1st October 2024

Interested Party Reference number: 20048864

1. Summary

WCSP Ltd have been catching and processing Queen Scallops (also King Scallops) in the eastern Irish Sea since 1971, currently employing over 100 people at our processing site and 30 fishermen who rely on the health of the Queen Scallop fishery. We **object** to the proposal as its area overlaps important Queen Scallop beds of the eastern Irish Sea fishery as well important spawning and nursery ground for this species. Current proposal measures do not go far enough to respect this important fishery. The fishery is one of 4 global Queen Scallop commercial fisheries, therefore Morgan OWF raises significant socioeconomic and market implications and this is especially the case if considered in tandem with the developer's other Mona OWF proposal which will develop on the other most commercially important Queen Scallop beds of the eastern Irish Sea. There are also no mitigation measures proposed to financially compensate Queen Scallop operators for any unforeseen consequences such as short or long-term habitat loss. We consider that the proposal in its current state presents a possible **Moderate or Major** (leanin

Figure 1.3: Indicative location of Scallop Mitigation Zone.

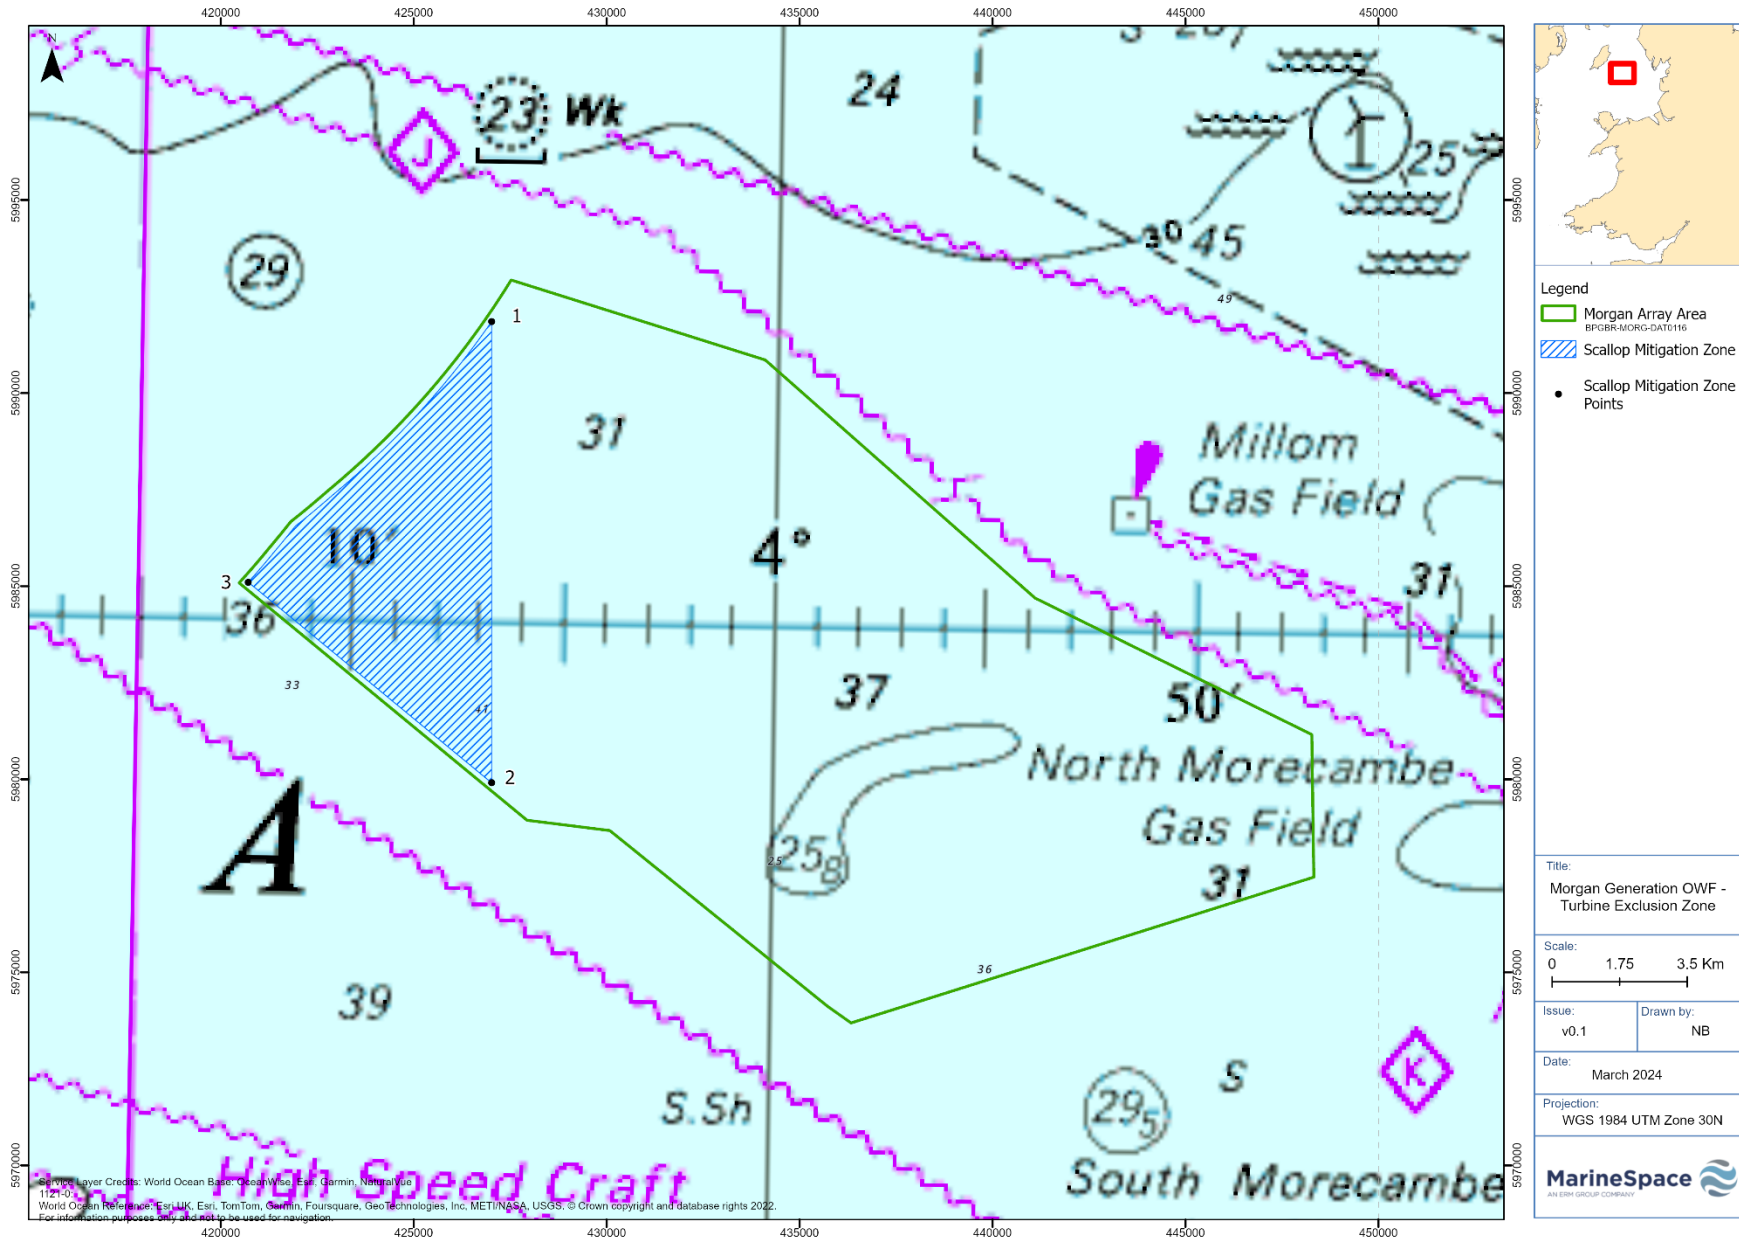
The Scallop Mitigation Zone is presented as a triangle which is a sufficient area which correlates with the bulk of the fishing data we provided through previous consultation with the developer. The proposals and Coexistence plan however contains details which reveal that it will not be an effective SMZ and fishing vessels will encounter practicalities which will affect safety and fishing access. The flaws identified with the SMZ are as such which fishing businesses such as ourselves find difficult to agree with as being a true SMZ : -

1. Rows of WTGs along the northwest and southwest perimeters of the Scallop Mitigation Zone
2. Associated WTG Interconnecting cables along the perimeter of the SMZ
3. Probable routing of cables through the SMZ

Our concerns over the nature of the SMZ are further shown in the map below which in the view of fishing businesses such ourselves will present a '**fishing on a postage stamp**' scenario in the future.

Red arrows indicate elements of the SMZ of concern in terms of perimeter rows and associative cable route

On paper it could be perceived as a substantial sacrifice of the proposal area by the developer, however the finer details are clear that it is going to present a fishing access issue. We have no issues with WTG infrastructure along the east perimeter of the SMZ as this was to be expected; however the SMZ as presented at the moment will affect fishing and flowing connectivity with the ground and tows to the south.

Analysis of WTG row positioning between points 1 – 3 and points 3 – 2 of the diagram will inflict the following fishing challenges. In terms of points 1 and 3, this is a prolific fishing area for Queen and King Scallops along the Isle of Man territorial sea limit. There is however further concern for continuity of fishing between points 3 and 2 as a row of turbines along this perimeter would cut existing Queen and King Scallops tows in half where vessels at the present would be fishing north to south in and out of the Morgan area. This is emphasized and explained by the plotter screenshot below:

- A commitment to bury cables to a greater depth than at present of 0.5m. Also to reflect the relevant method of fishing carried out in this area, we would also request that Scallop dredging over trawl surveys are carried out following burial/completion. This would ascertain successful burial and safety for fishing vessels.
- Commitment to removal of northwest and southwestern WTGs bounding the SMZ Scallop Mitigation Zone
- The document suggests the Scallop Mitigation Zone is indicative and will be refined which makes us further cautious about what the end result shall be. There needs to be a real commitment in this regard.
- A commitment to not take cables through the Scallop Mitigation Zone.
